WAYNFLETE LOWER SCHOOL - ADDENDUM #2

date: Monday, February 06, 2017
project: Waynflete Lower School Addition & Renovations, 2013-0050
prepared by: Austin Smith Scott Simons Architects
to: Cordelia Pitman Wright Ryan Construction
Rick Bergeron Wright Ryan Construction
Luke Dione Wright Ryan Construction
Anne Hagstrom Waynflete School
Patrick Boure Waynflete School
Phil LaClaire PML Project Management

Subject: Addendum #2 to Bid Documents of January 12, 2017

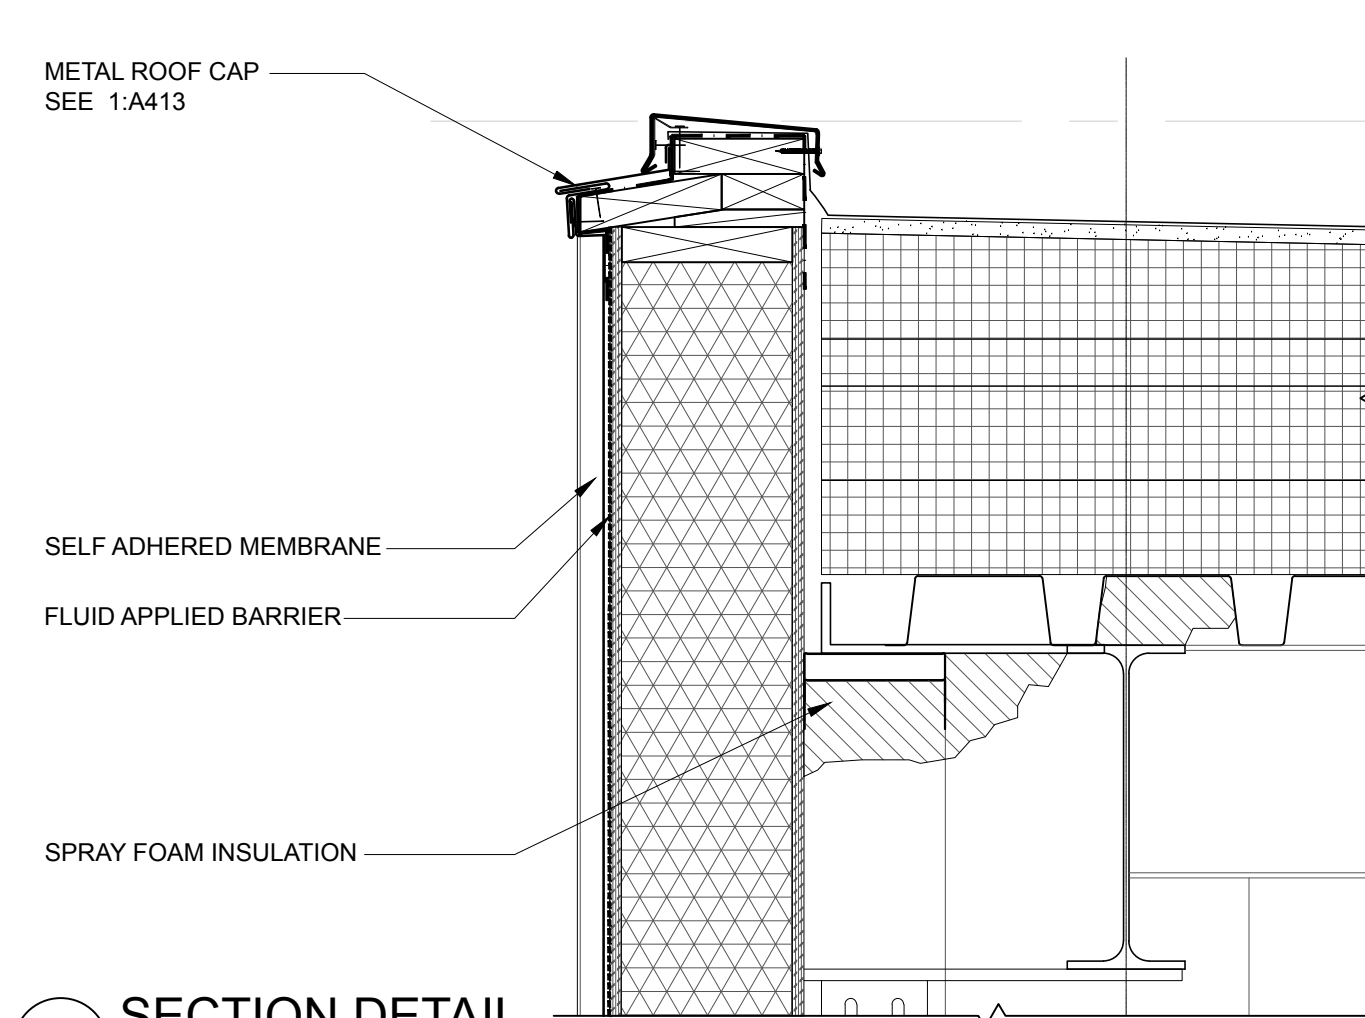
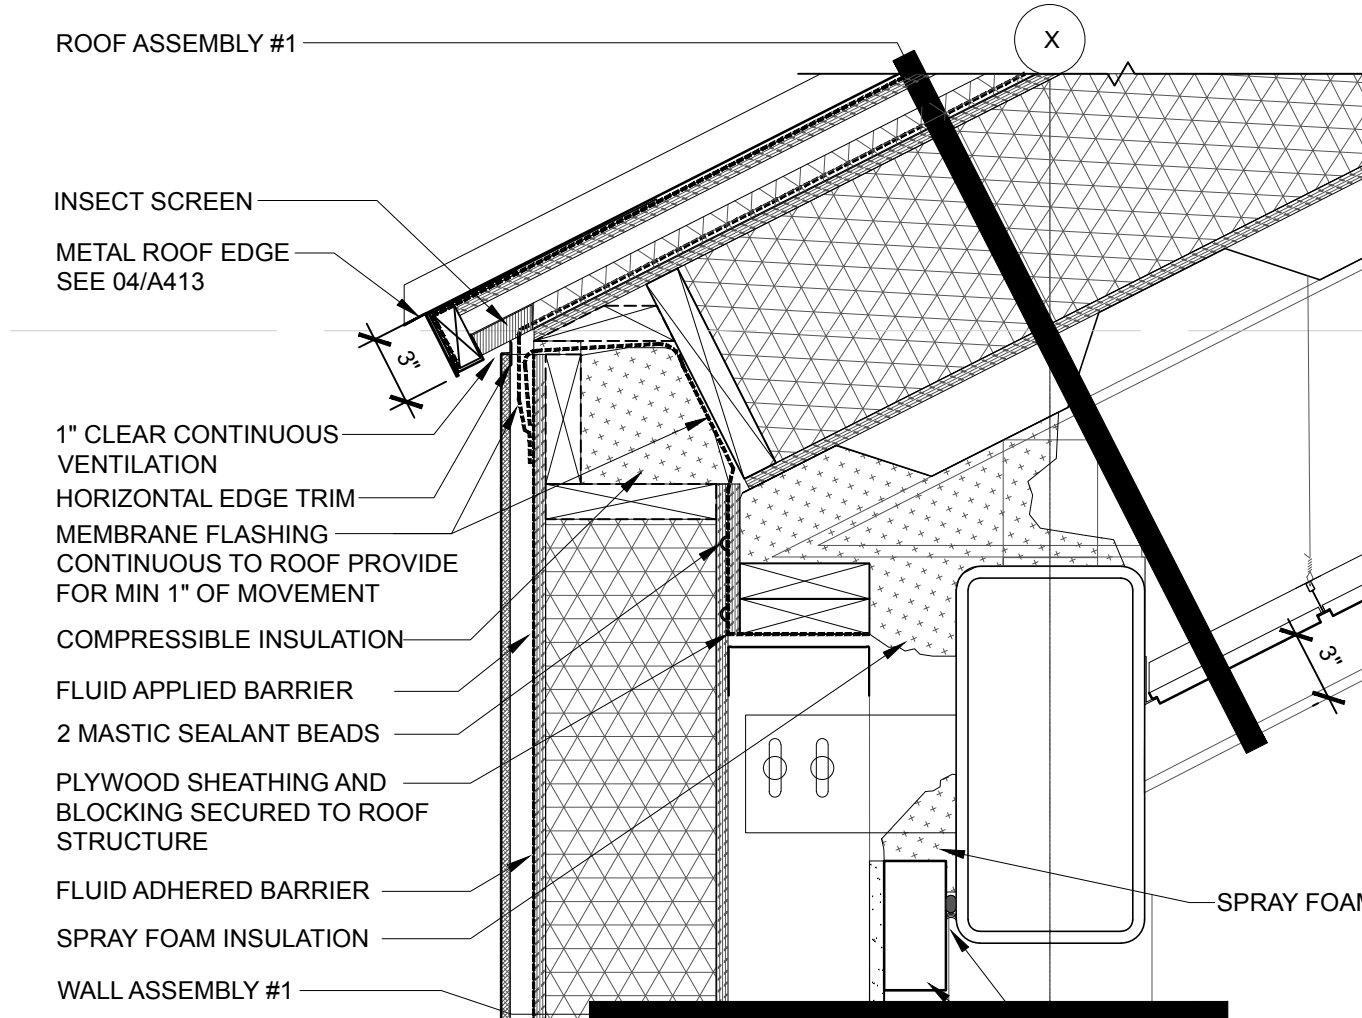
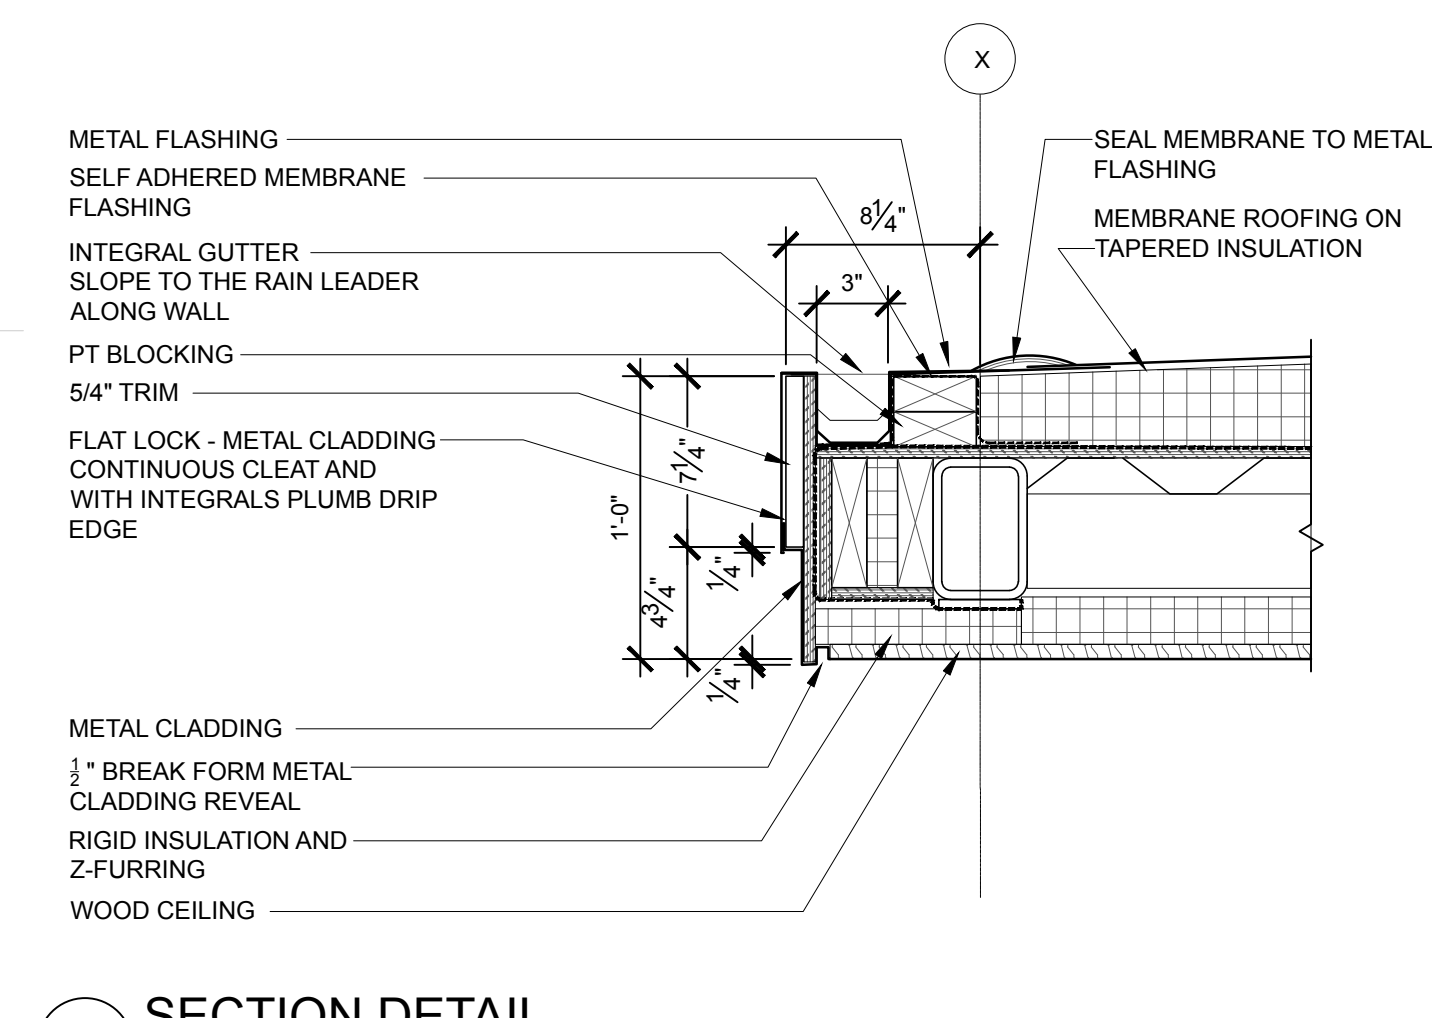
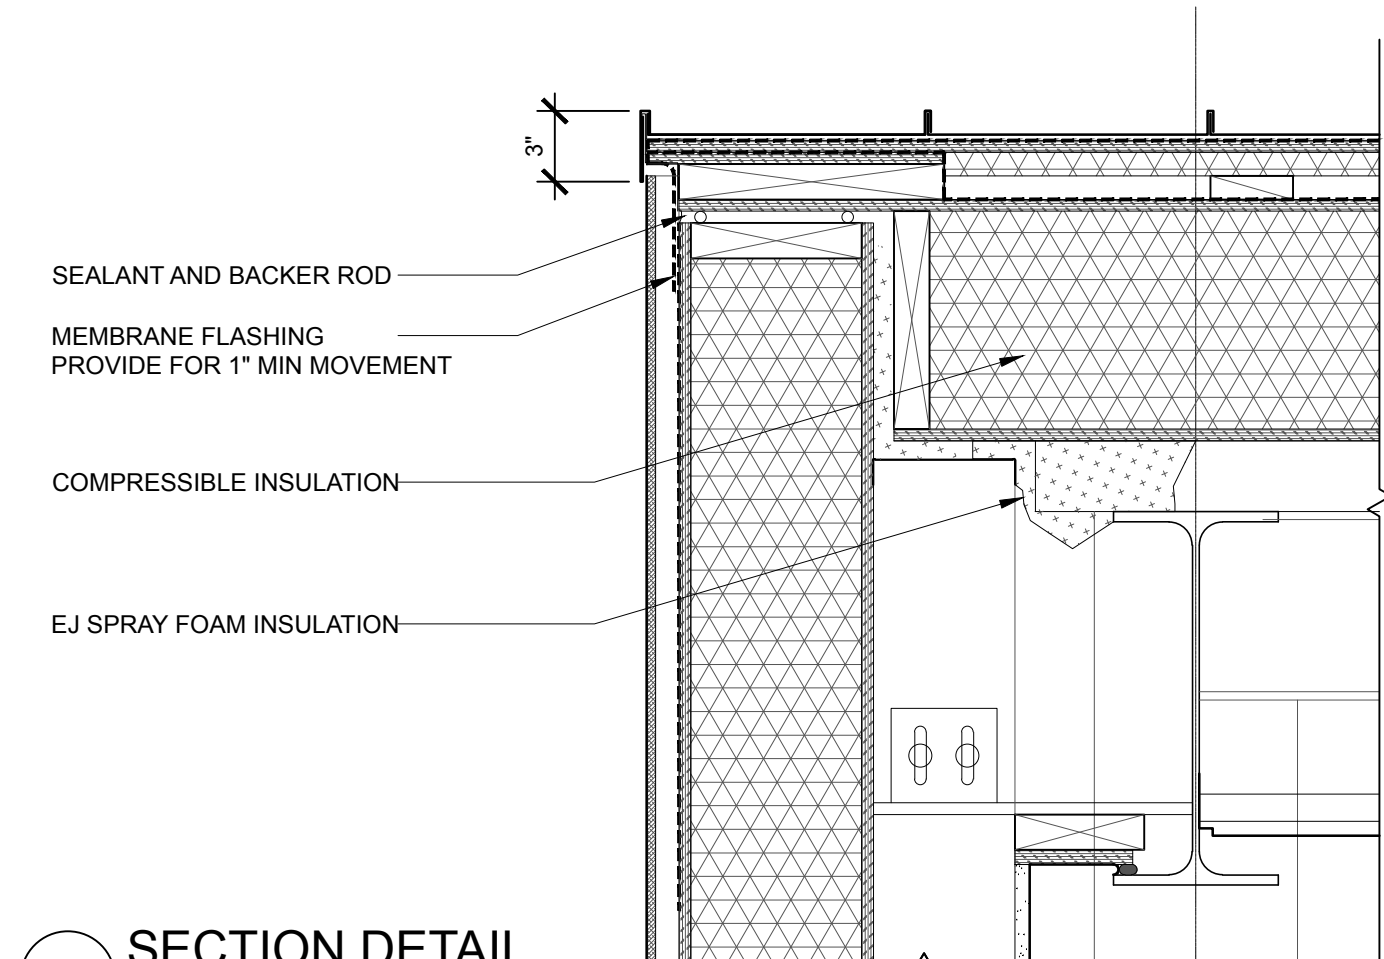
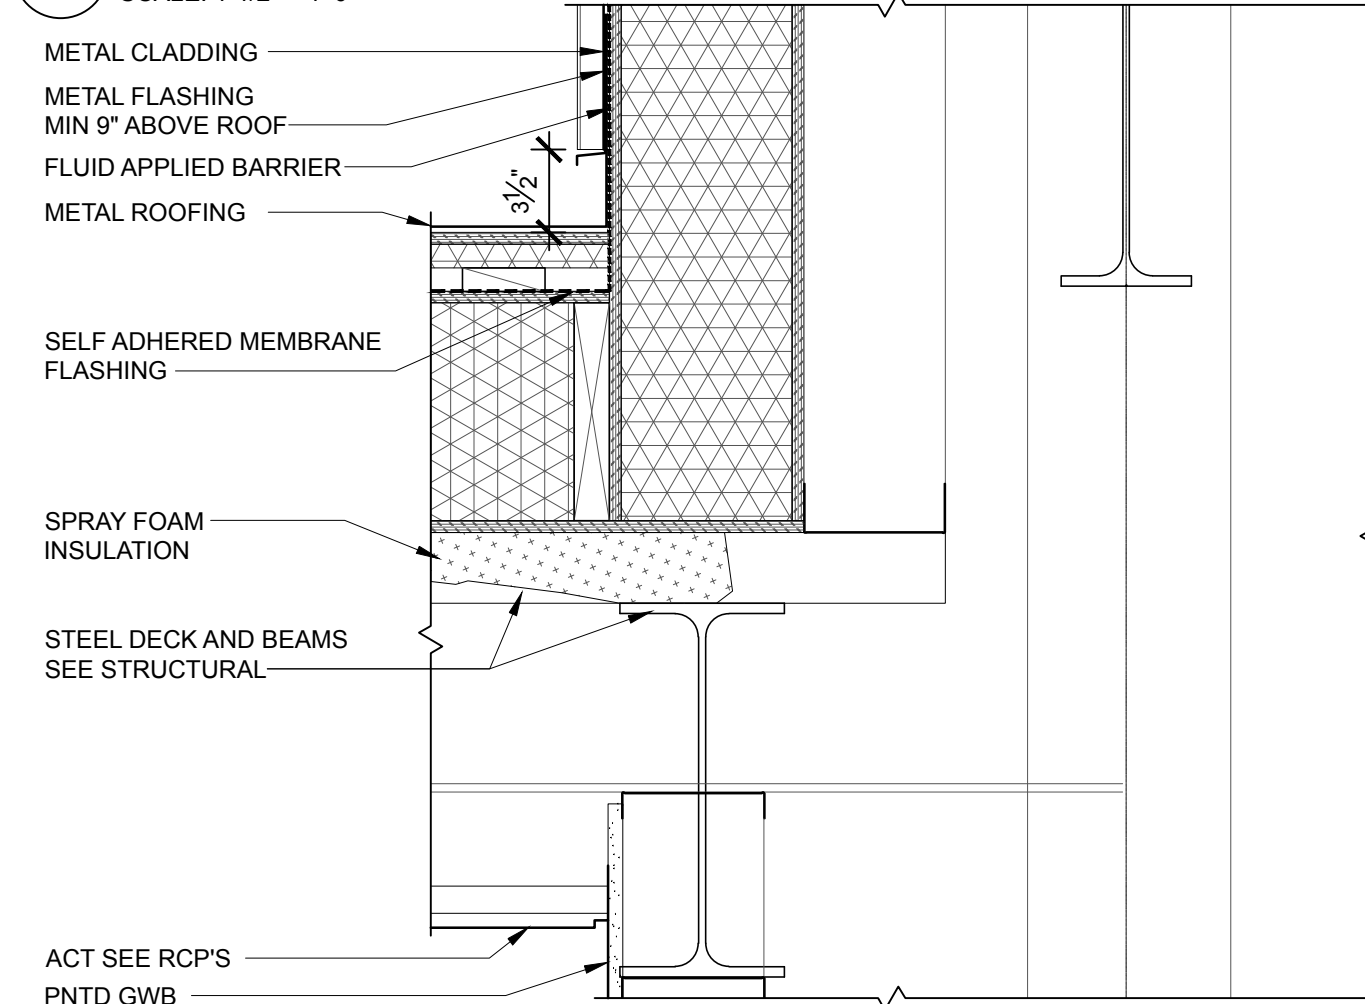
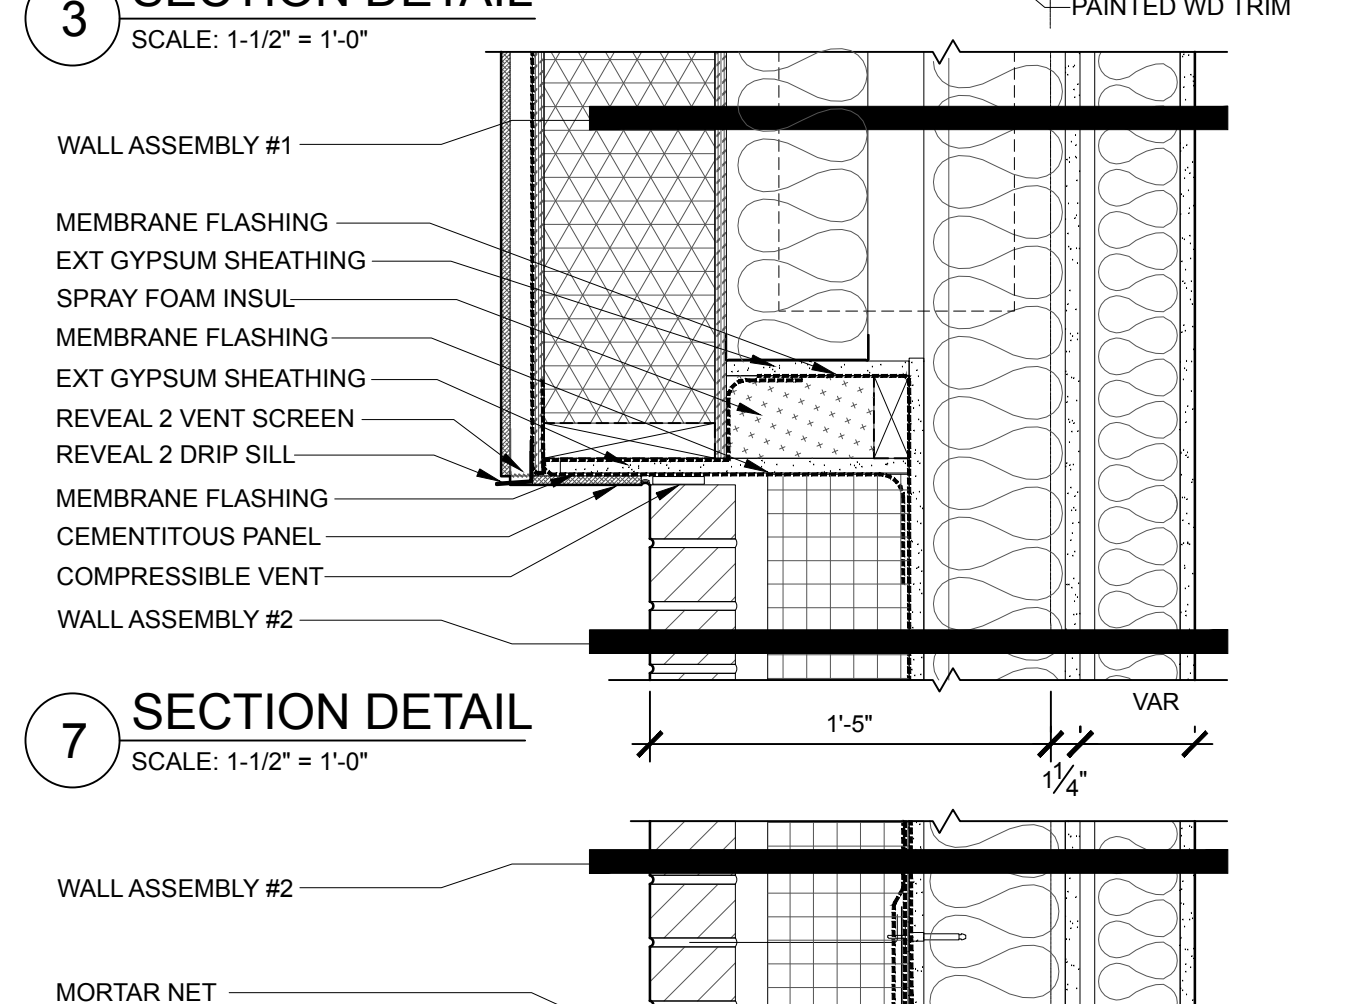
- 2-Q3 Question 3 Q: 4. Detail 7/A401 states “Typical Venting Trim” at the fiber cement siding. We carried typical solid Fry Riglet trim extrusions. Please clarify. Is the Fry Riglet trim to be clear anodized or painted the same color as the panels?
A: All trim pieces used with the Hardie Reveal 2.0 Panel System are part of the siding system and supplied through the siding manufacturer. Trim pieces to be field painted with the siding panels.

- 2-Q7 Question 7 Q: Drawing A401 Detail 2 indicates a wrapped column condition as typical. Details 7 and 8 on the same page do not show a wrapped column condition. Where does Detail 2 occur?
A: Detail 2 / A401 occurs only at exterior columns with the exception of Col. J11. Interior columns receive a painted finish.
